OAKLANDS FARM SOLAR PARK

Schedule of changes to the draft Development Consent Order
December 2024

Document Ref: EN010122/D8/3.4

Important Hedgerows Plan

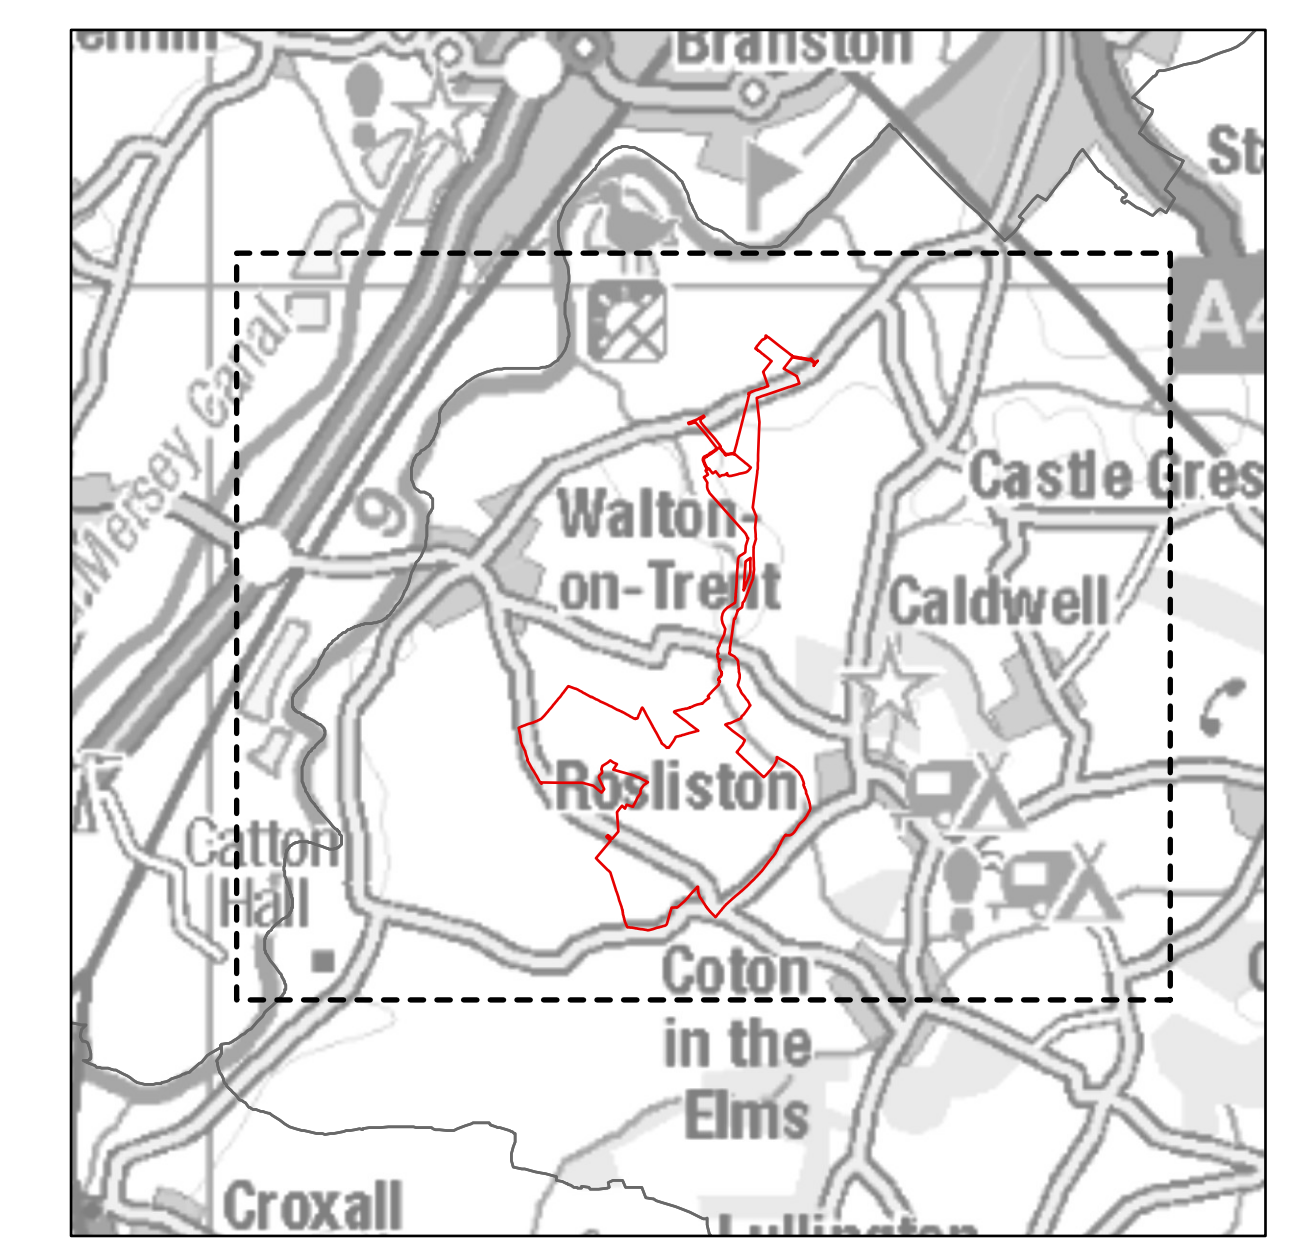
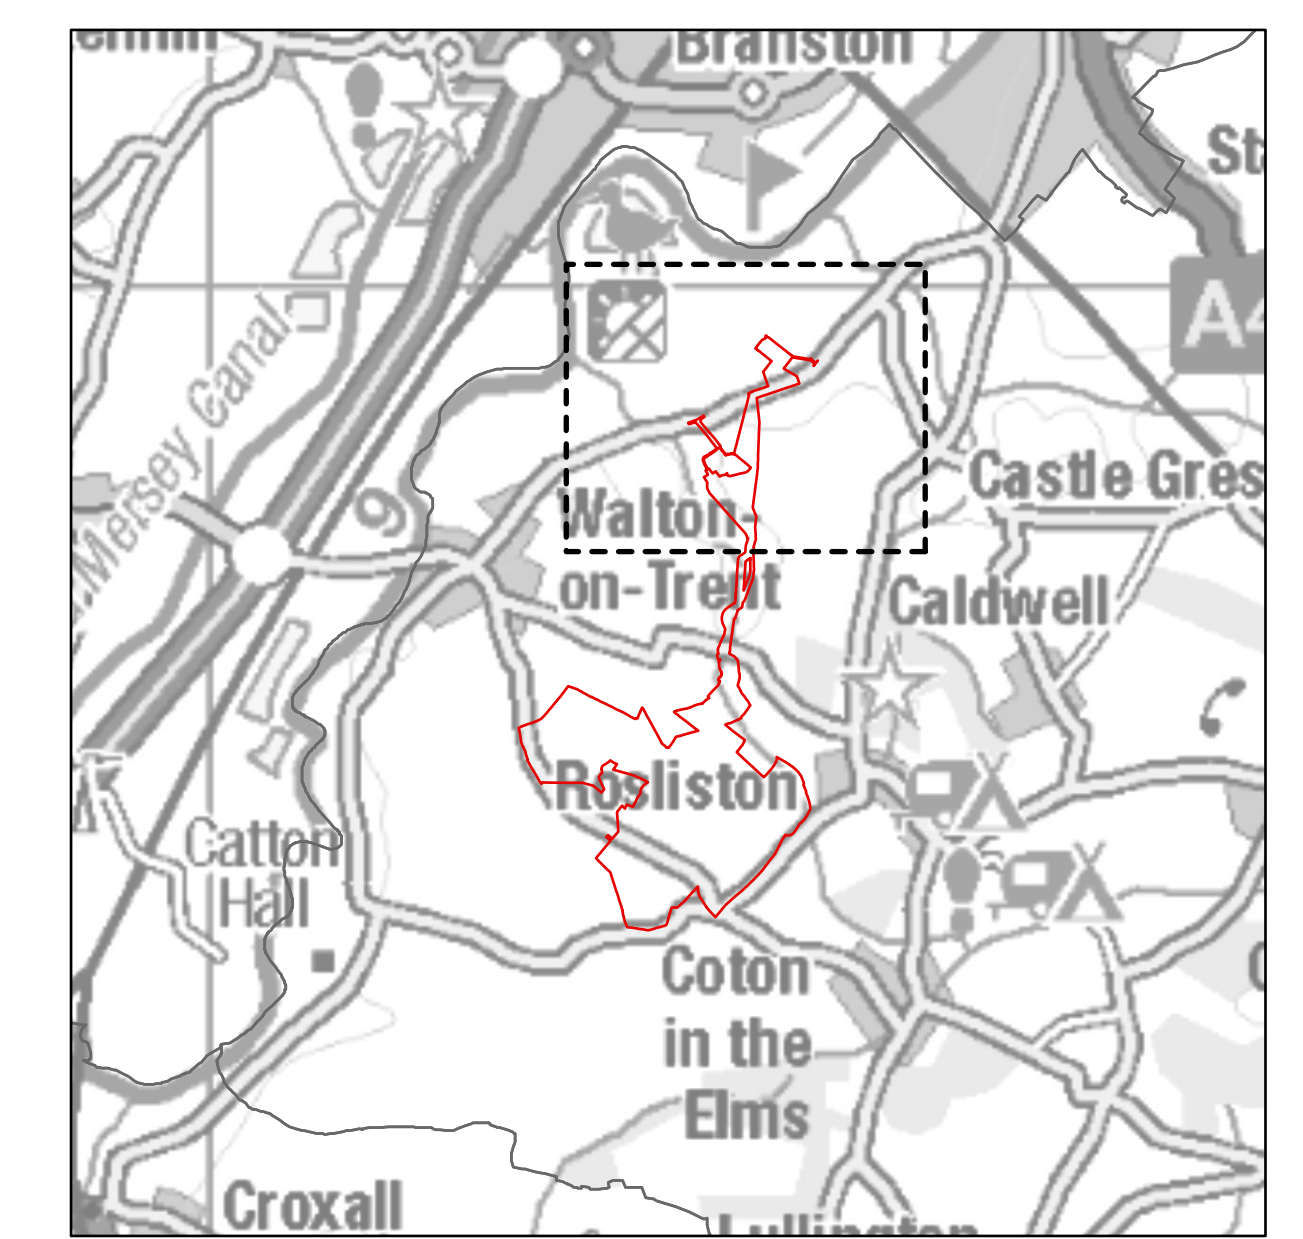
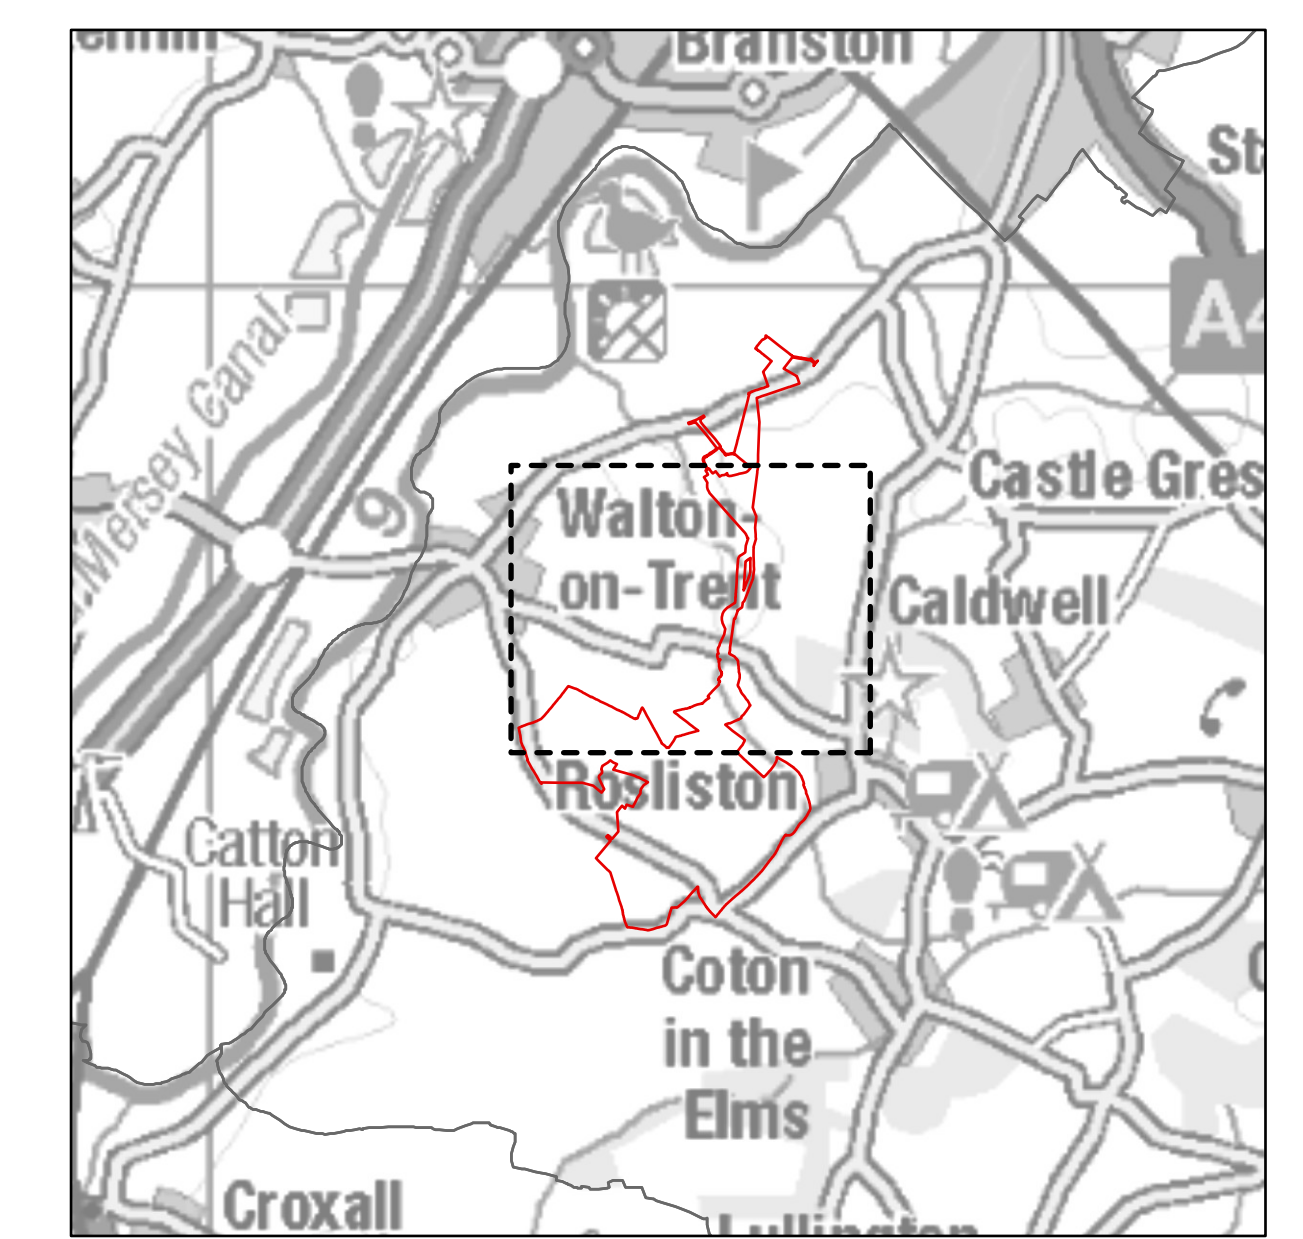
Article 35(1)	The description of the plan at Article 35(1)(b) has been updated to “important hedgerows plan”. The reference to the “archaeological management plan” has been removed.	To correct drafting errors.
Schedule 1, Part 2, R4(2)	The words “The scheme submitted pursuant to sub-paragraph (1) must include a timetable for the construction of the phases of the authorised development and a plan identifying the phasing areas” have been added.	As explained in the Applicant’s Deadline 1 submission and its response to ExQ 1.8, this paragraph has been added to Requirement 2 to prescribe that the written scheme setting out the phases of construction of the authorised development to be submitted and approved under sub-paragraph (1) includes a timetable for the
